## **Development Facilitation Team (DFT) – Review Comments**

**Project No: PR-2020-004596      Date: 03/27/2024      Agenda Item: #3 Zone Atlas Page: D-10**

**Request: PRELIMINARY PLAT EXTENSION FOR 30 ACRE DEVELOPMENT TO INCLUDE 162 TOWNHOME LOTS, 1 MULTI FAMILY RESIDENTIAL LOT WITH 175 APARTMENT UNITS AND 1 COMMERCIAL LOT WITH A TOTAL OF APPROXIMATELY 21, 955 SQUARE FEET OF BUILDING SPACE. PRELIMINARY PLAT ORIGINALLY APPROVED MARCH 29, 2023 BY THE DRB.**

**Application For: SD-2024-00045-EXTENSION OF PRELIMINARY PLAT (DHO)**

PLAT OF
UNIVERSE VIEW SUBDIVISION
 BEING A REPLAT OF LOT 1, BLOCK 8
 UNIT 17, VOLCANO CLIFFS
 LOCATED WITHIN SECTION 22, TOWNSHIP 11 NORTH
 RANGE 2 EAST, N.M.P.M.
 CITY OF ALBUQUERQUE
 BERNALILLO COUNTY, NEW MEXICO
 NOVEMBER 2022

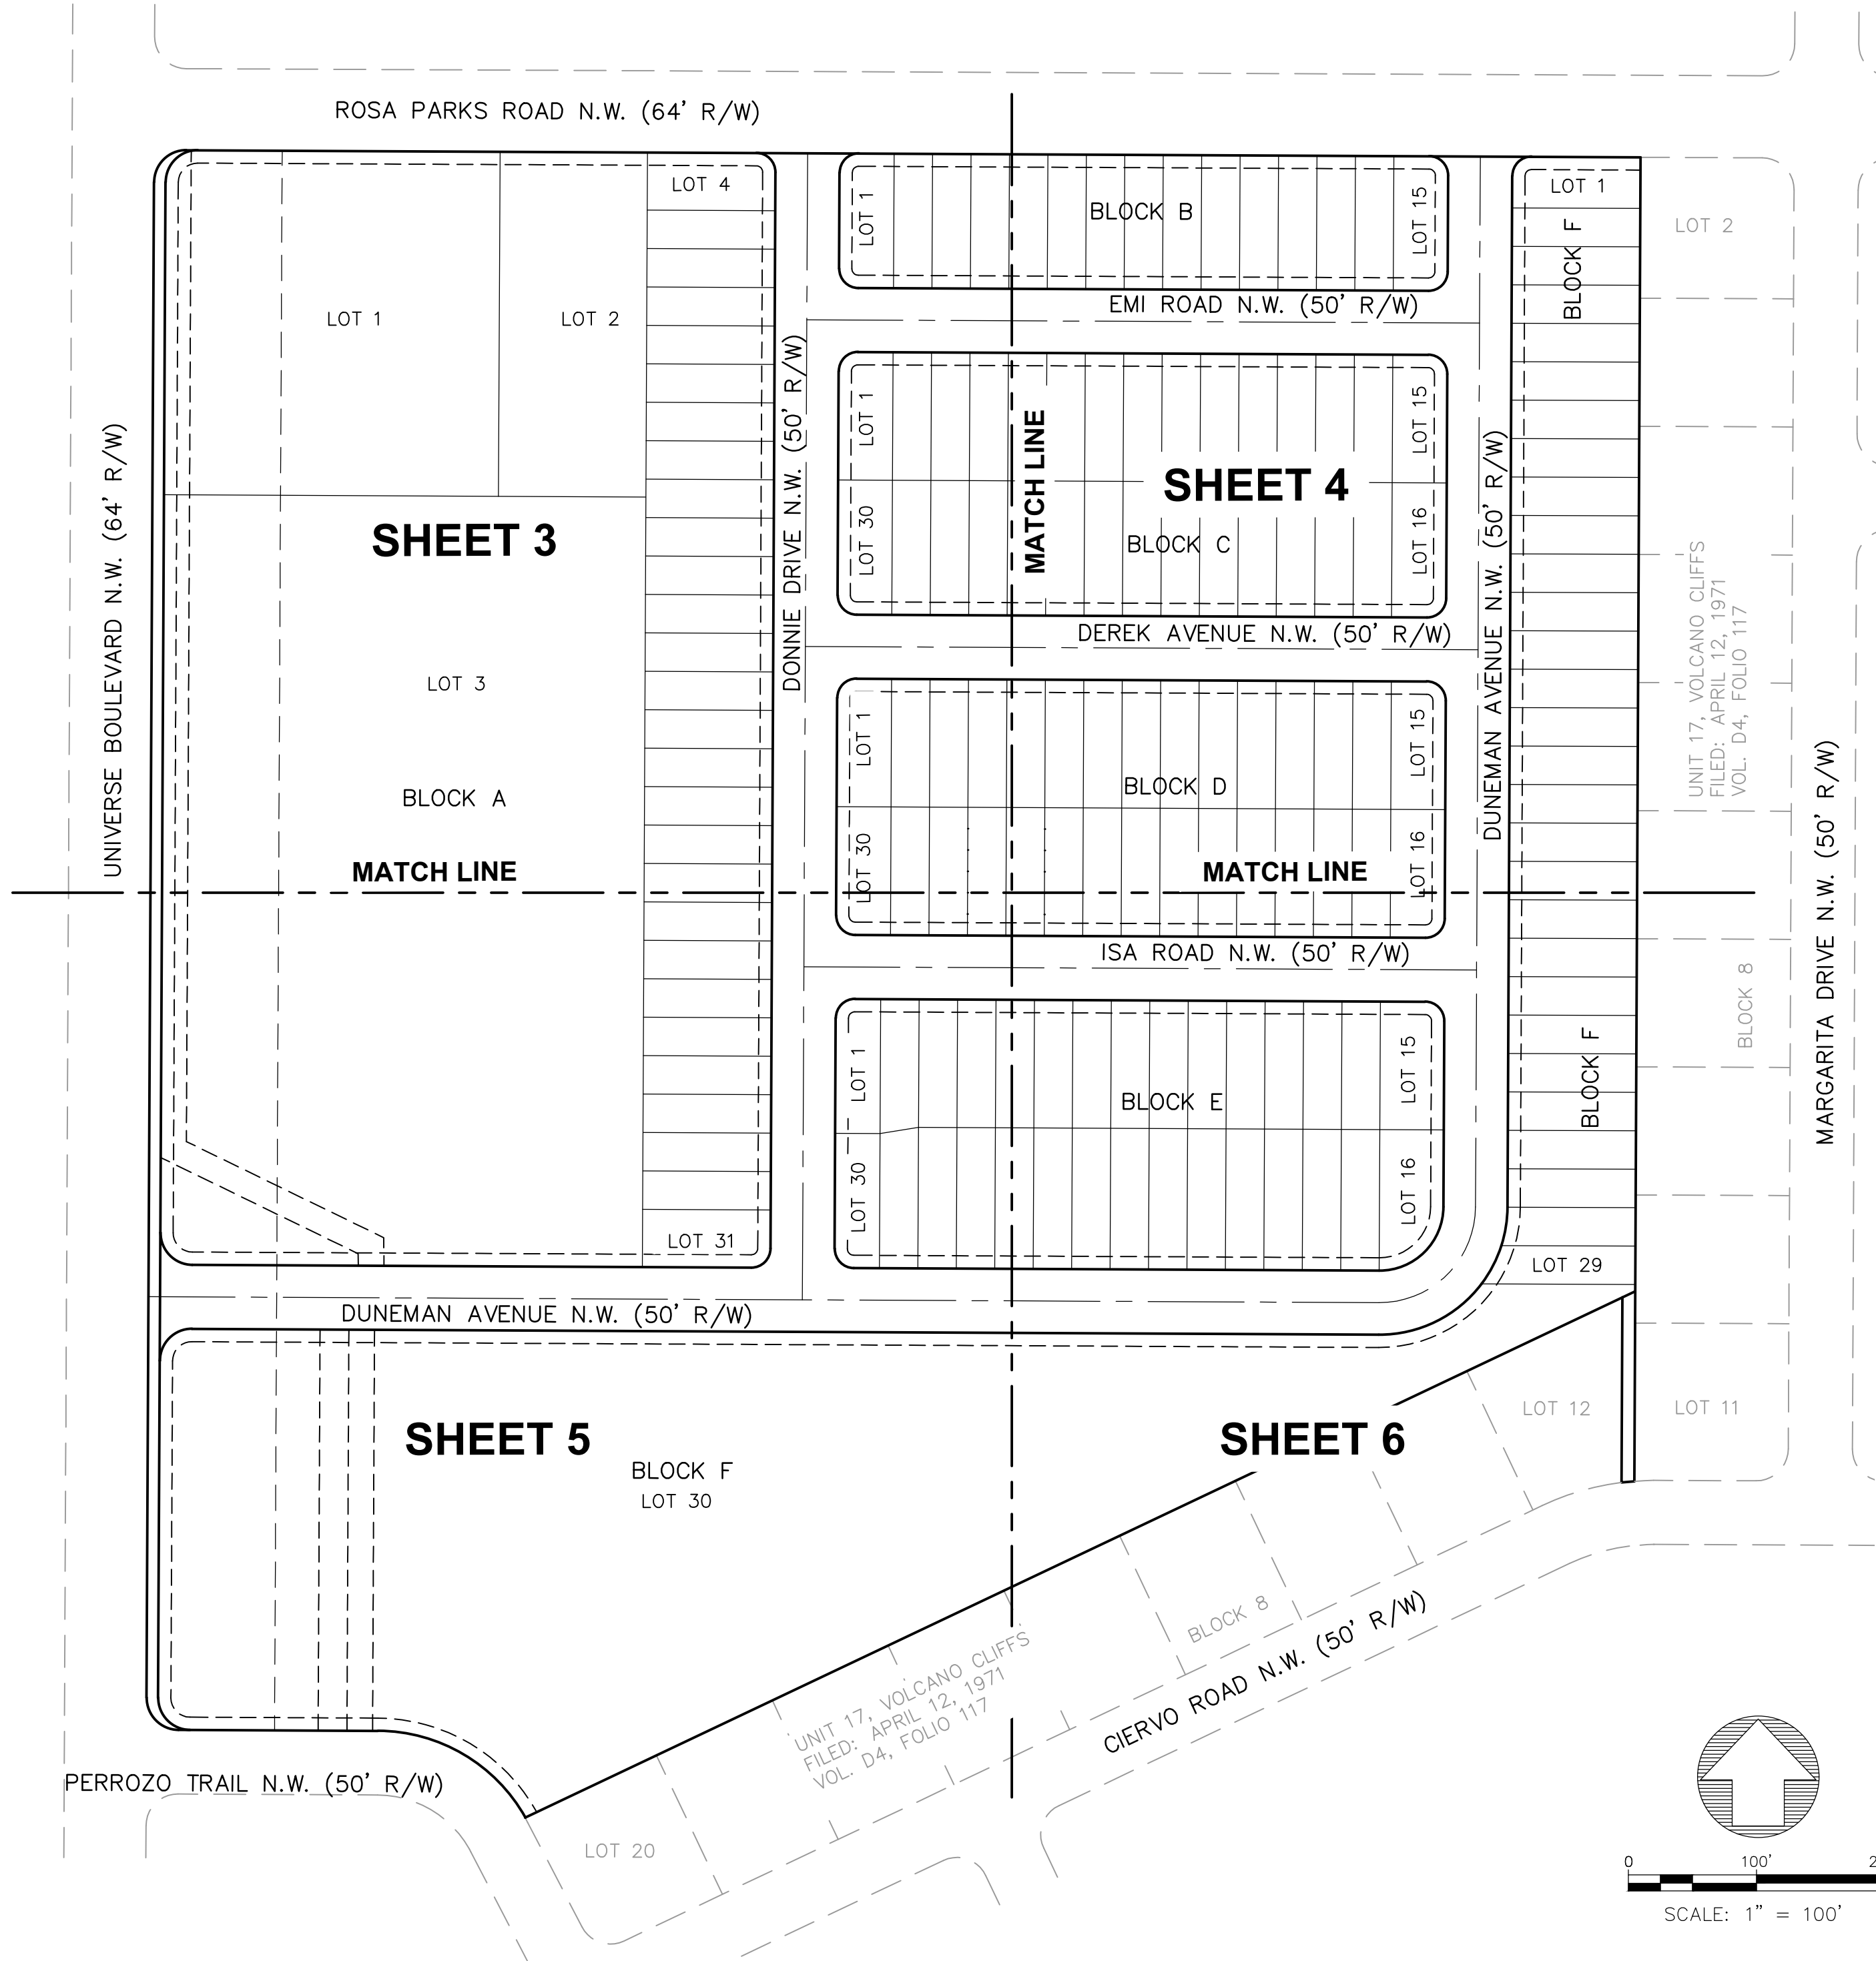
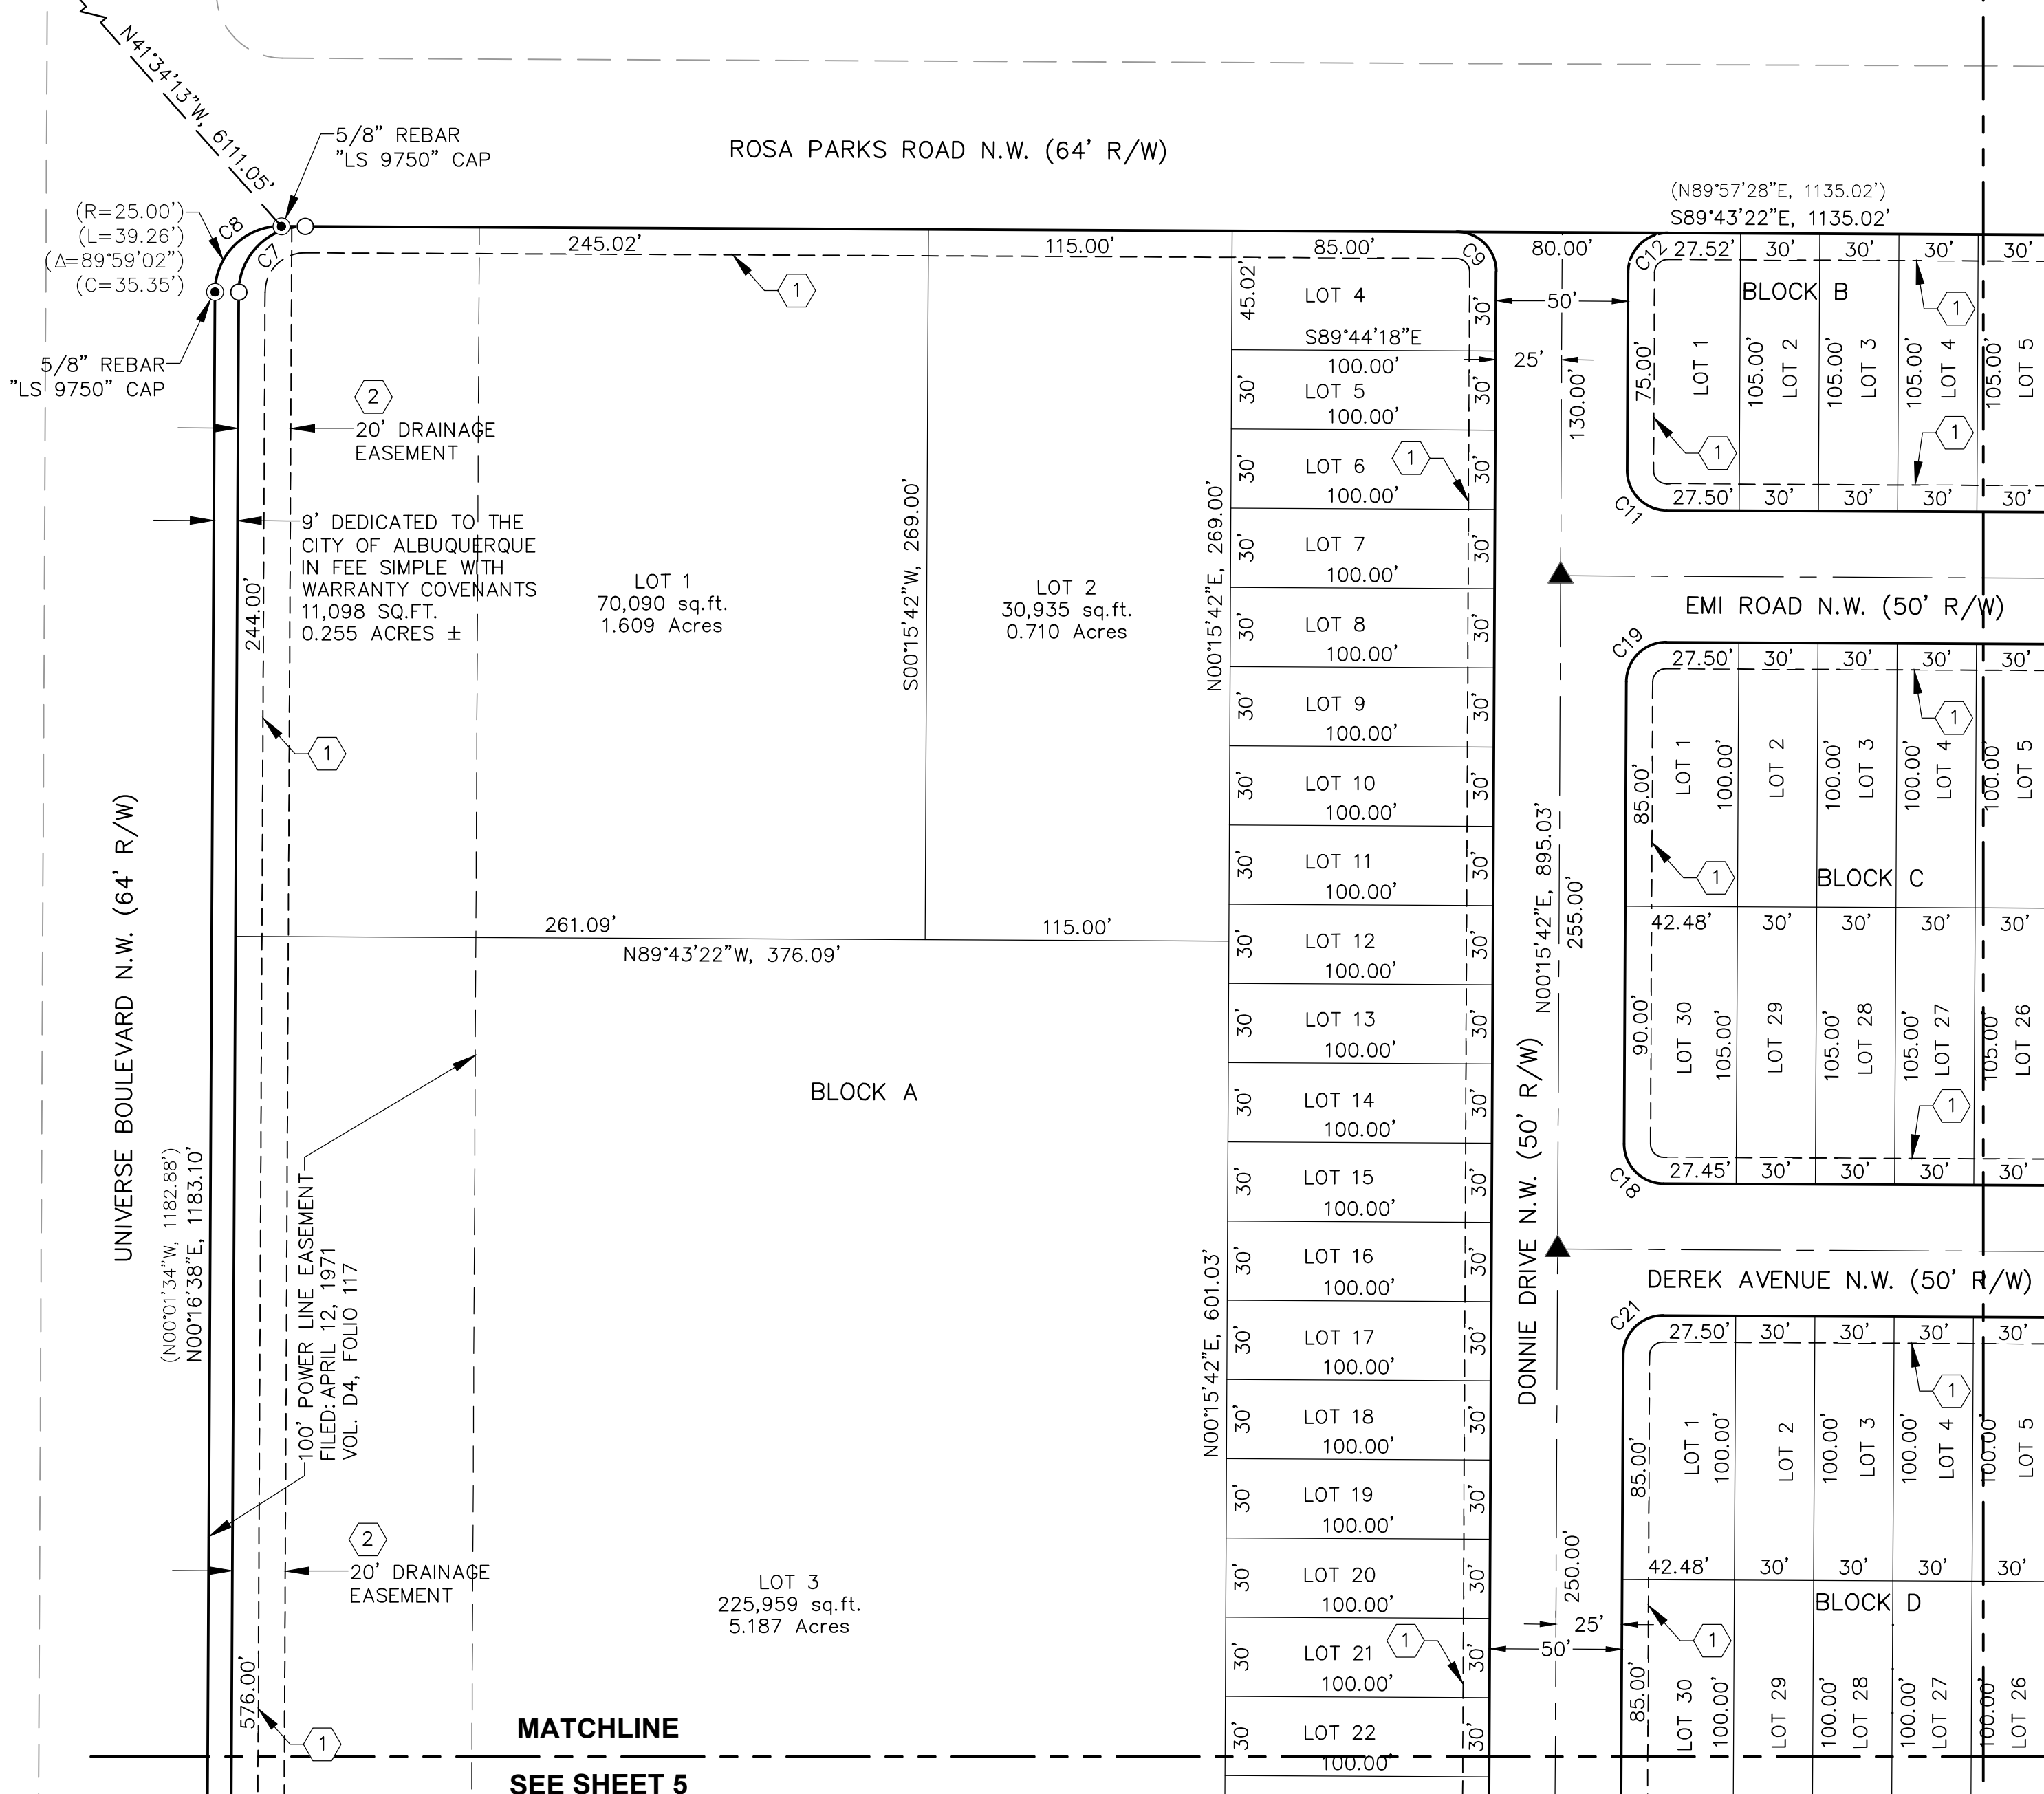
3. **Development** standards of CPO-13 include Façade Design, Building Design, and Garage access limitations (*including rear-load access for townhomes*). It is not clear in this plan that this has been accounted for – please clarify how townhome units in this plan would be accessed.

**Table 5-4-1 limits block lengths on local streets to 600 feet. Block 'F' townhomes is greater than 600 feet. Lots 4 thru 31 create a block greater than 600 feet.**

**5-4(F)(2)(b) Residential lots shall avoid layouts where the rear lot line is adjacent to a collector or arterial street.** Local frontage roads may be used within a subdivision to avoid locating residential rear yard walls along collector and arterial streets. **In the layout presented, rear lot lines are on local streets.**
